**Transport  
for NSW**

**Exhibition of Environmental Assessment for Homebush Bay Bridge (MP10\_0192)**

Thank you for your letter dated 16 March 2012, requesting comment on the Environmental Assessment of the proposed Homebush Bay Bridge, between Rhodes and Homebush Bay West.

Figure 3.7 – Lane configuration options

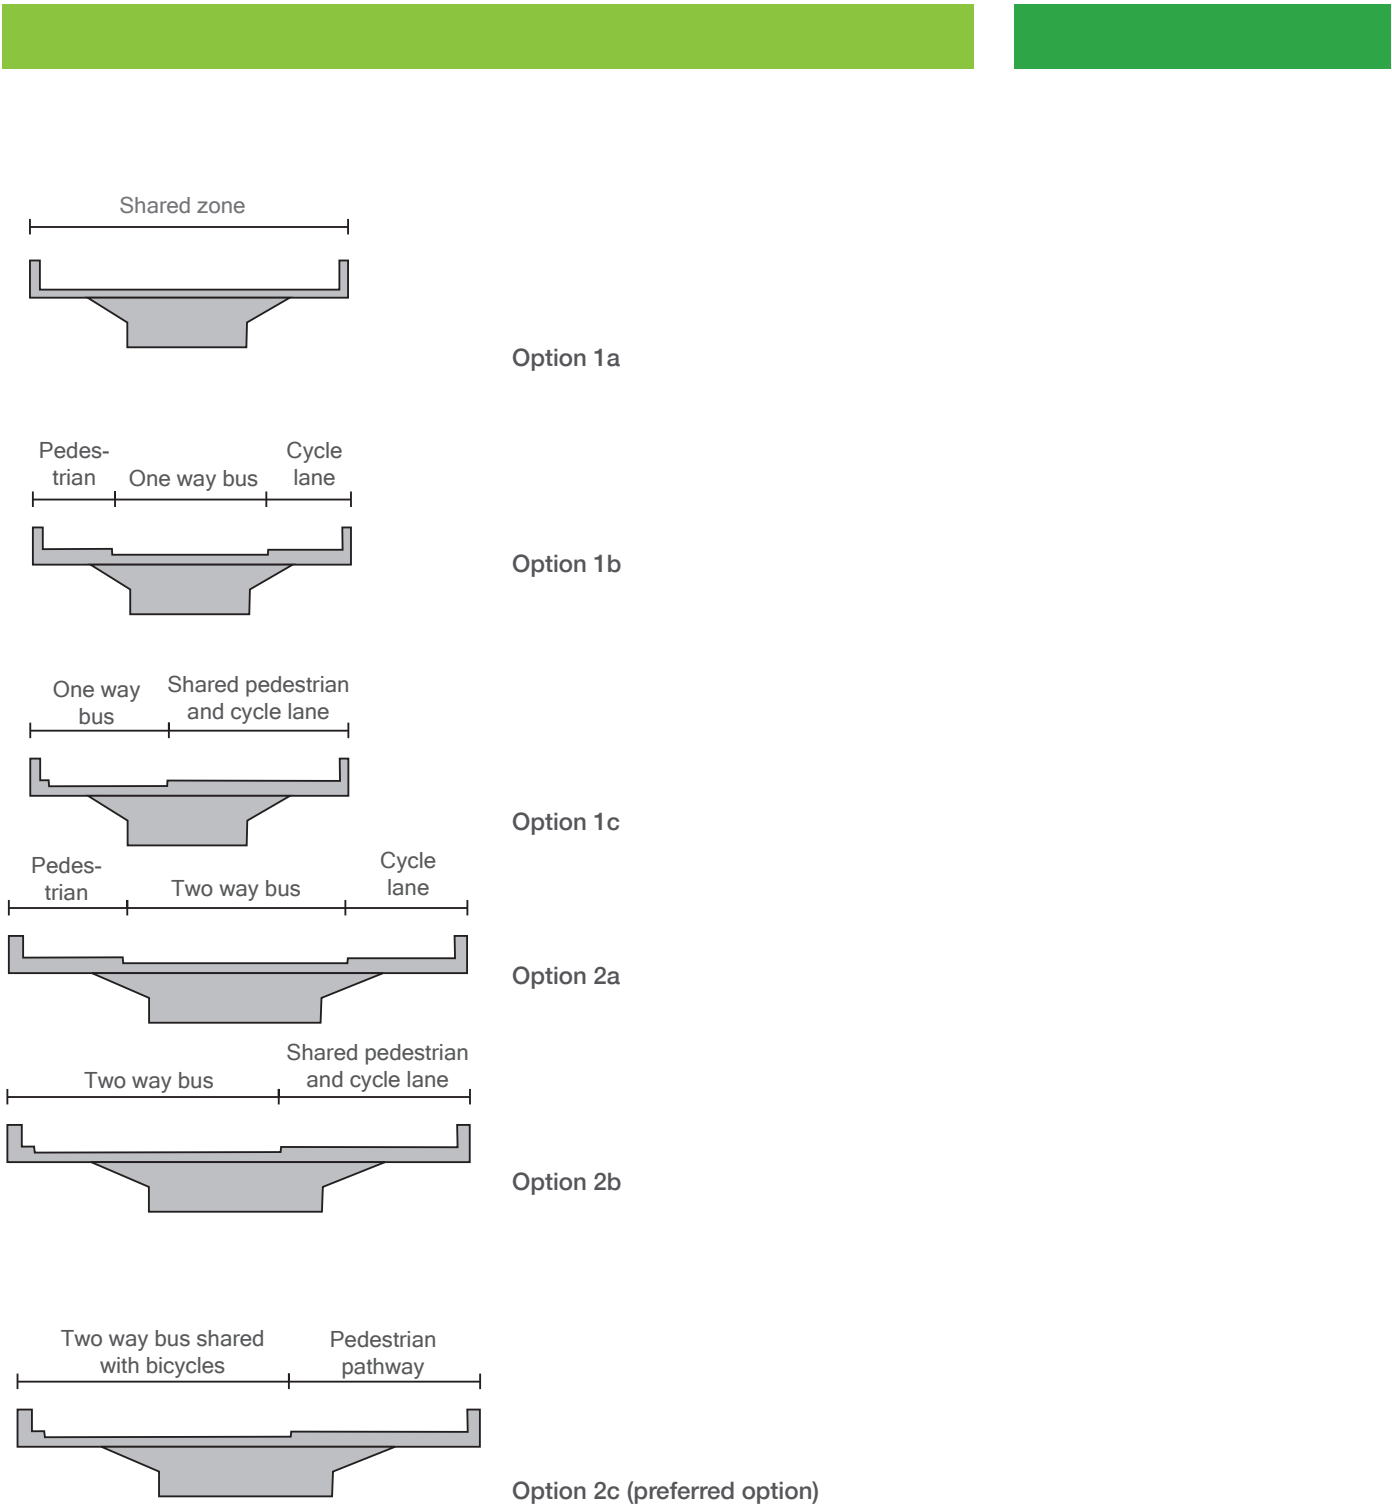
Transport for NSW supports the safety benefits in providing the proposed separation of pedestrians from cyclists. However, a shared path may be a better option for this bridge given that younger children riding bikes, skateboards and/or scooters, and inexperienced adult cyclists who are not confident riding in traffic next to heavy vehicles, are likely to ride along the pedestrian path.

The high speed differential between cyclists and buses (especially uphill on the approach road) is of concern with respect to the safety of cyclists. Buses and service vehicles are likely to drive close to the speed limit given the lack of traffic, which will create conflict

and/or frustration when these vehicles are limited by bicycle speeds. This may increase the safety risks to bicycle users as the heavy vehicles seek to move around bicycle users.

Transport for NSW recommends that the developer give further consideration to the provision of a bridge based on options 2a or 2b. Should option 2b be preferred, careful consideration should be given to the available width of clear path on the narrower approach road and around seating.
